Consultation Response KC Landscape

Planning Number:	2023/93464		
Proposal:	Discharge of conditions 4 (Phase II report), 5 (Remediation Strategy), 8 (Construction Environmental Management Plan), 9 (CEMP: Biodiversity), 10 (road condition survey), 11 (estate roads), 12 (Lingards Road footway), 13 (highway retaining walls), 14 (highway embankments), 15 (Stability Remediation Strategy), 16 (drainage infrastructure in highway), 17 (drainage scheme), 18 (flood routing), 19 (temporary drainage), 20 (Arboricultural Method Statement), 21 (bridge details), 22 (green retaining wall), 23 (Ecological Design Strategy), 24 (ecological measures), 25 (materials), 26 (footpath connections), 27 (landscaping) , 28 (lighting), 29 (temporary waste arrangements), 30 (pedestrian improvements), 31 (pedestrian improvements) and 33 (cycle parking) of previous permission 2020/93954 for erection of 42 dwellings and associated works		
Location:	Land at, Lingards Road, Slaithwaite, Huddersfield, HD7 5HY

NOTES/COMMENTS: Condition 27 (landscaping)

drawing no
R/2646/2

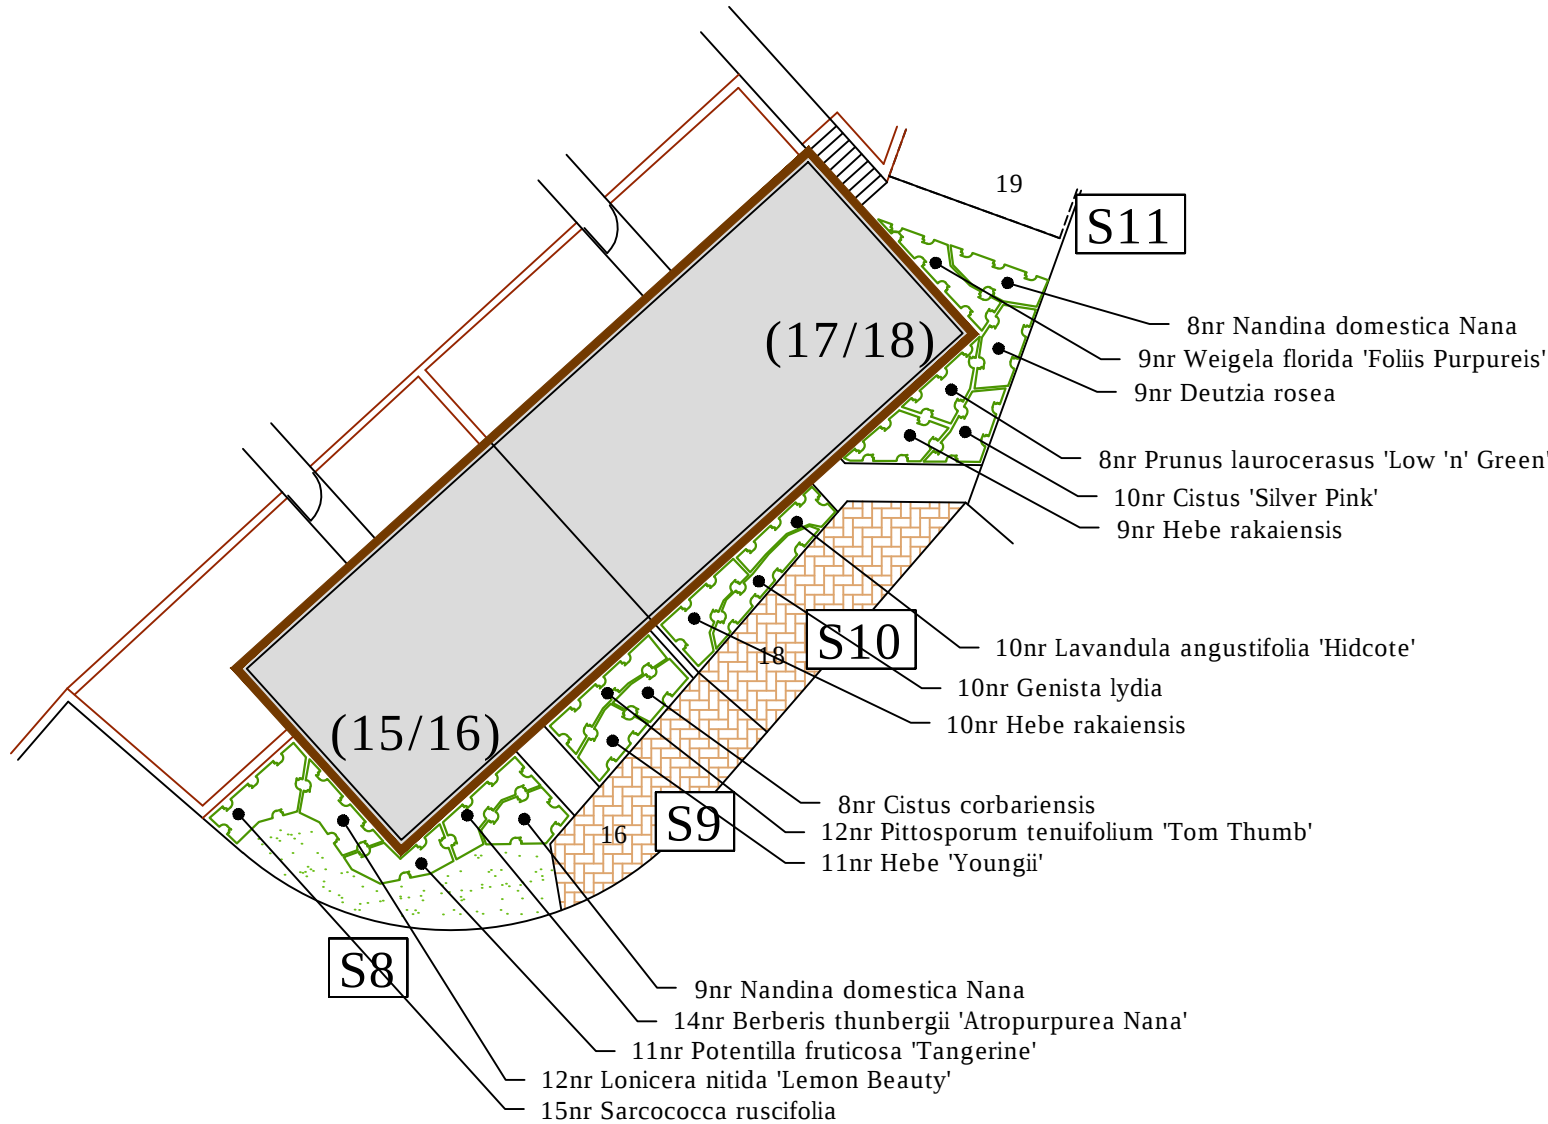
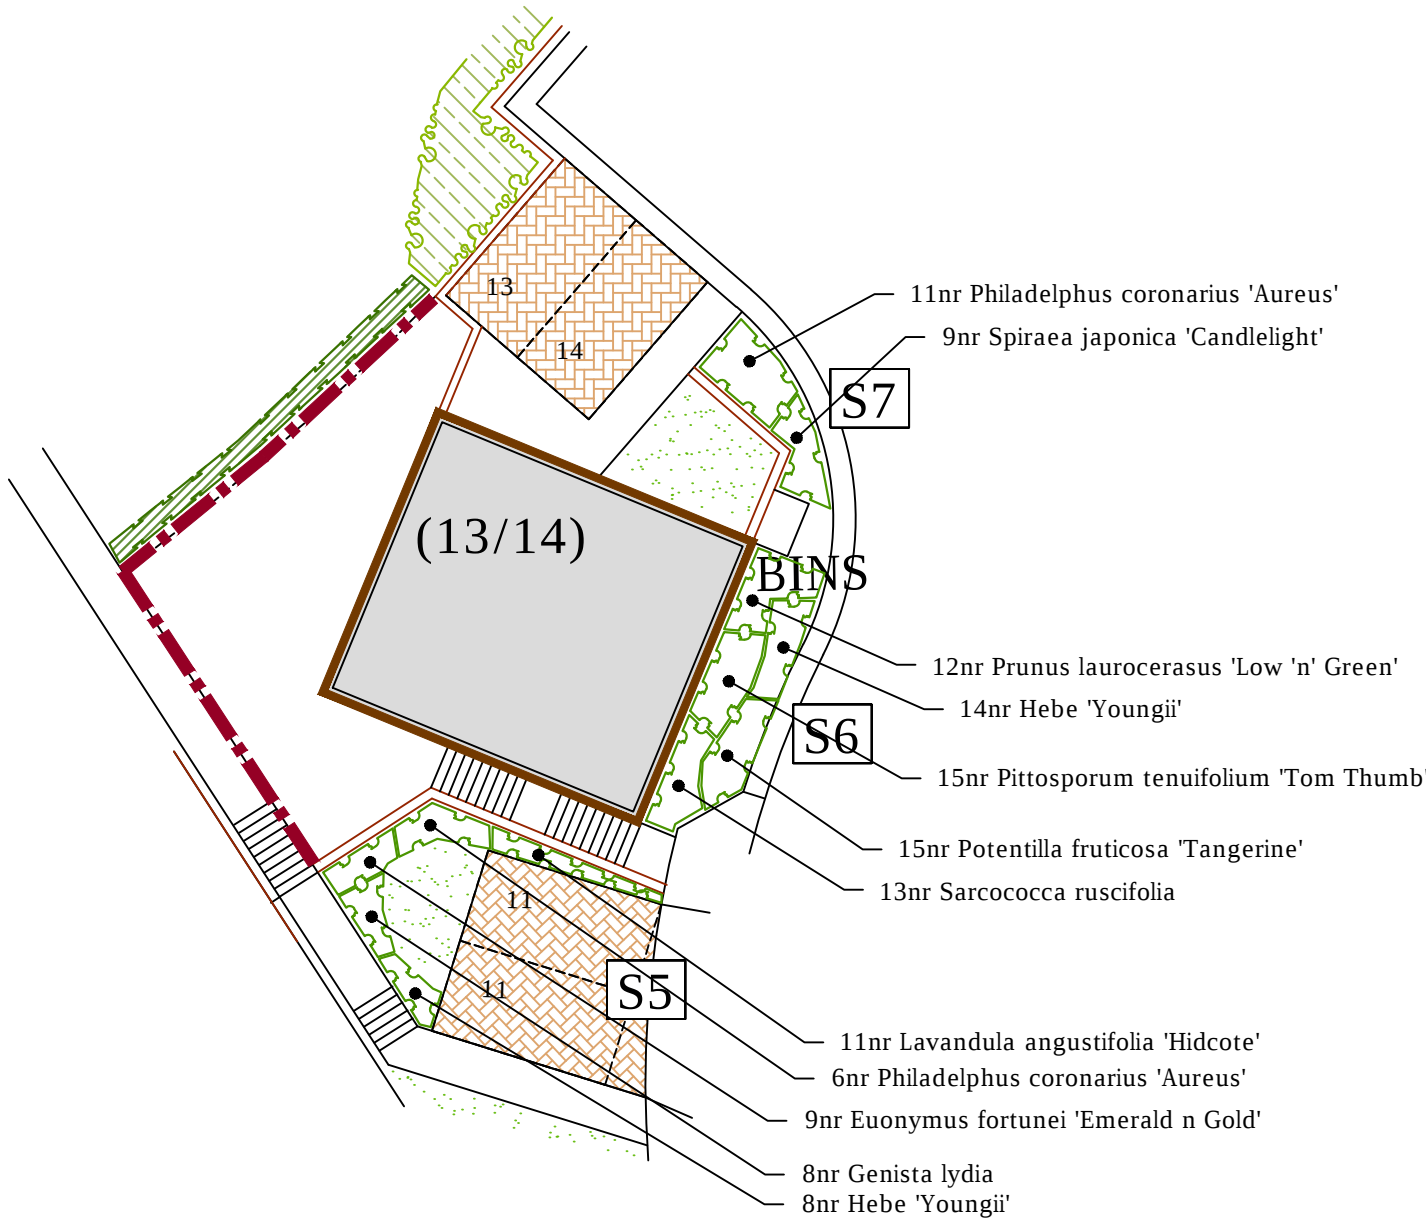
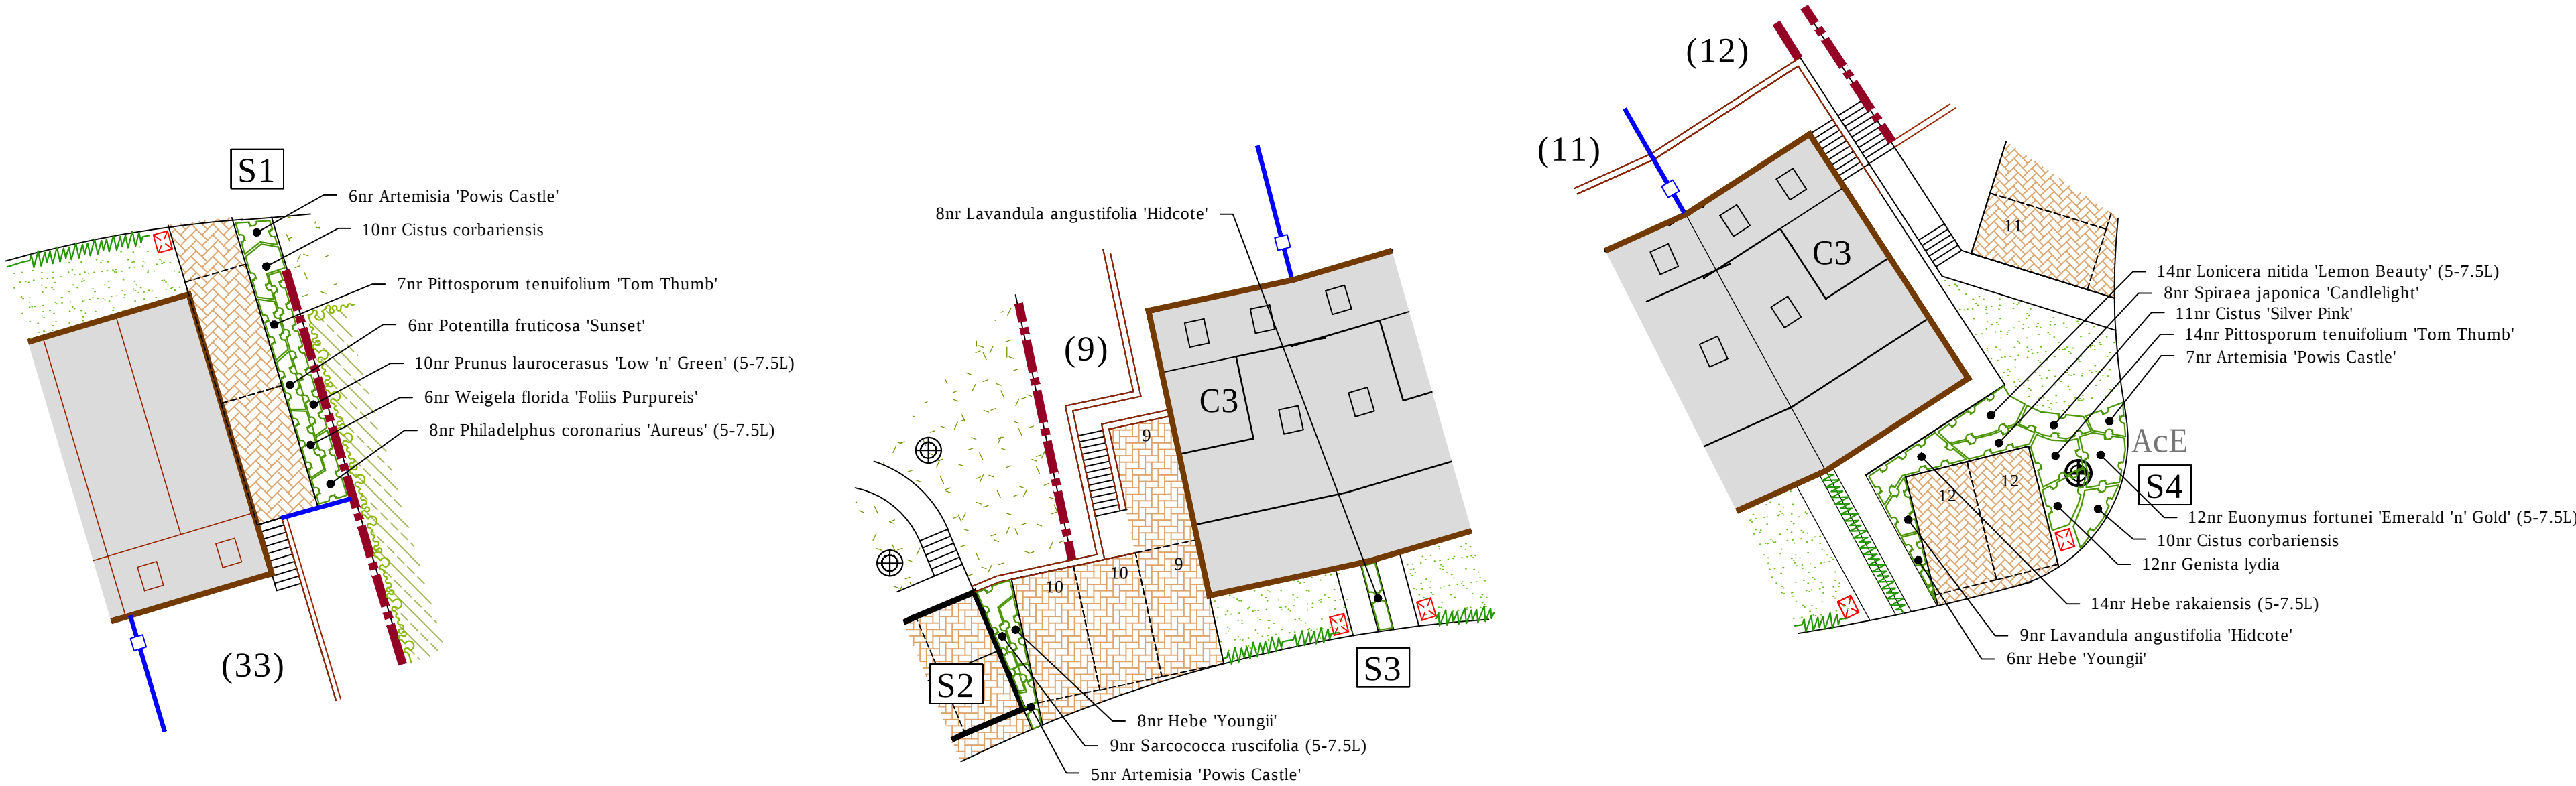
Most of the landscape information has been provided in detail, however, much of the plan is greyed out without sufficient detailed annotation relating to specifics within Condition 27.

Attention is drawn, but not limited to, to the requirements of a,a regarding the implementation of trees and hedgerow planting to the north boundary – this is greyed out, b,a and b,b is also largely greyed out for the western boundary and timescales of implementation required for item c.

All sections of the condition 27 should be adhered to.

We cannot recommend the discharge of this condition until further information is submitted; therefore Condition 27 must remain.
